To Department of Planning and Infrastructure  
GPO Box 39, Sydney, NSW,2000

From Roger Barker,  
PO Box 4281, Coffs Harbour Jetty NSW 2450  
Ph 0422 572 752

Re. Submission of Objection  
MP09\_0067

**1277-DR3**

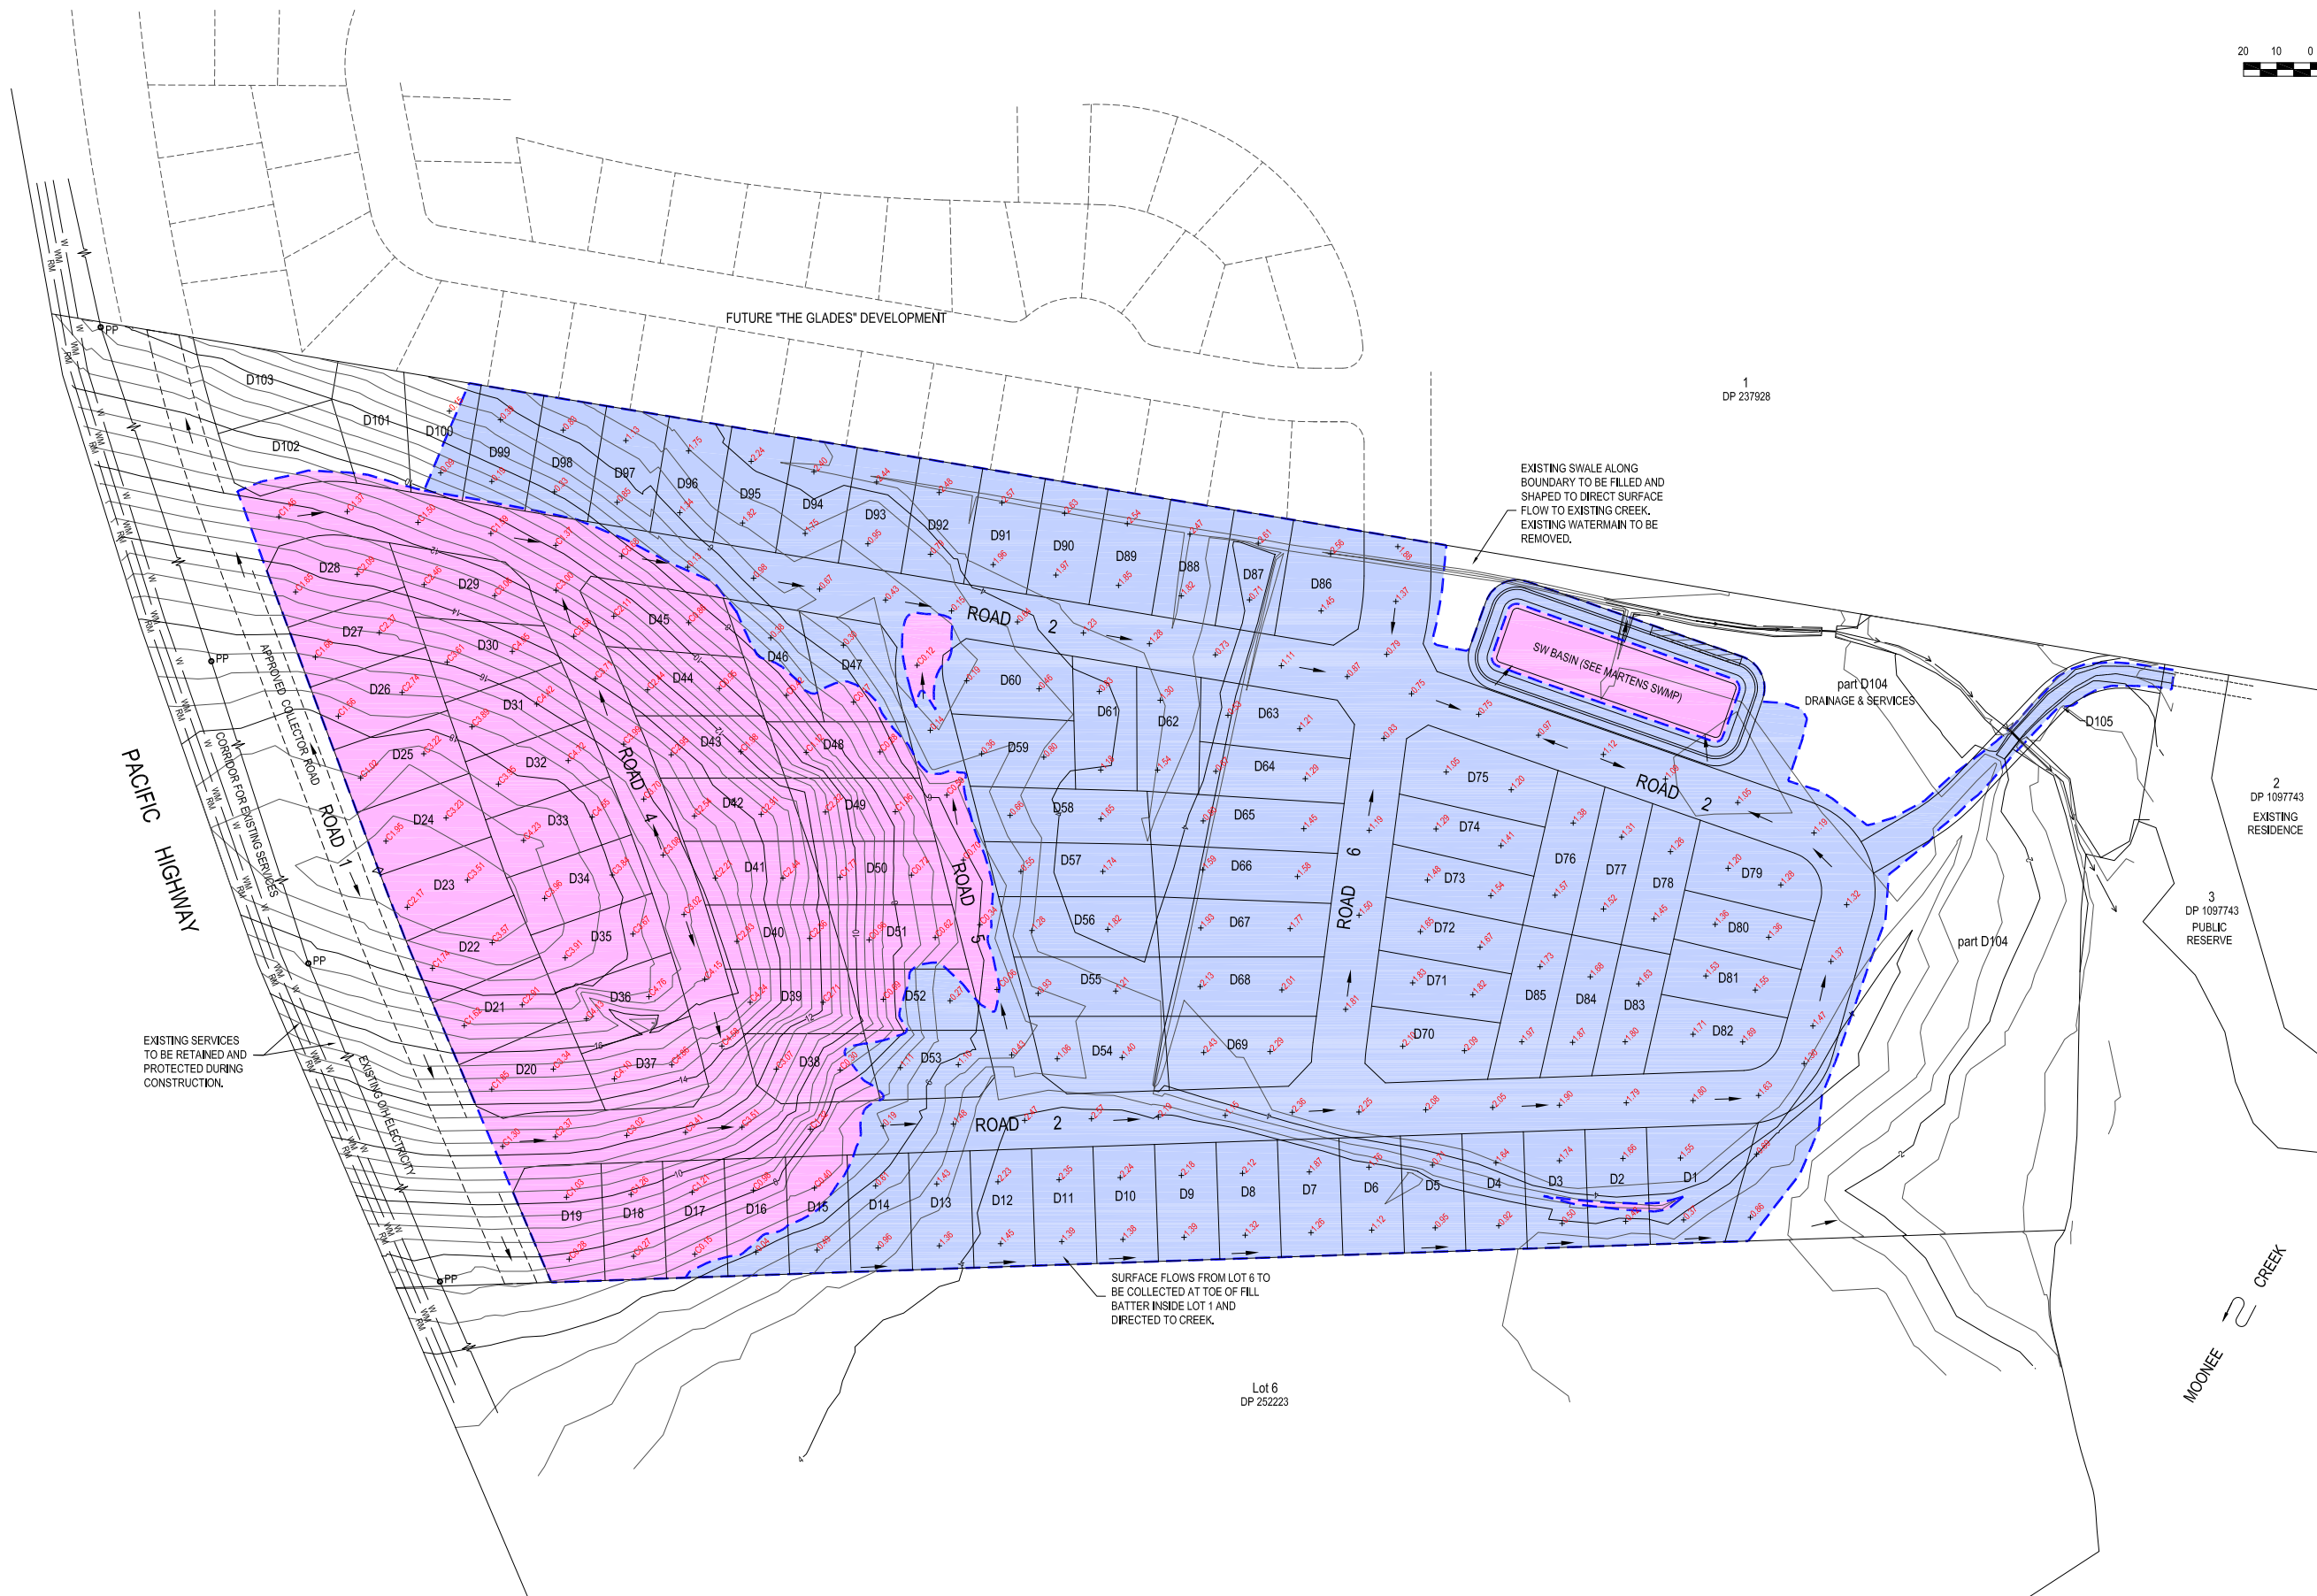
1/ I object to the Lot1 proposed Bulk Earthworks Plan.

Without discussion or consultation it proposes the removal of all remaining established vegetation from the Matcove property Lot1, on the western hill, much of which being established secondary Koala Feed of equal significance to any other in this precinct. The plan then proposes excavating 82,000m<sup>3</sup> to a depth of 4mtrs, which would require intensive rock breaking and many months of excavation, in close proximity to my Home Horses and Stables.

This industrious proposal to quarry excessive material from the heavily wooded knoll of predominantly Red Mahogany and Black Butt with established understory, to be transported to the lower level ground, to raise the natural ground level up to as much as 2.67mtr on the extremely low land of Lot1 Nth side, in the vicinity of a recent Osprey nest reestablishment, where Wallum Froglet Habitat has been identified in the DCP as potential, *for a reason*.

Up to and along my Nthn boundary, it is proposed to raise the ground level of Lot1 by up to 1.43mtr, flowing towards lot 6 in places, again without my consultation. It would possibly result in storm water inundation and raised water table impact on my land.

This earthworks proposal is totally unacceptable to me as both immediate neighbour and resident. It has negative ramifications proposing to create a lower land of my property in dispersion of Lot1 ecological pressures. **Ref.** Application MP09\_0067, Appendix K, Civiltech, sheet 3 of 8, Drawing 1277-DR3, issue B. And also the following plan 4 of 8. Issue B
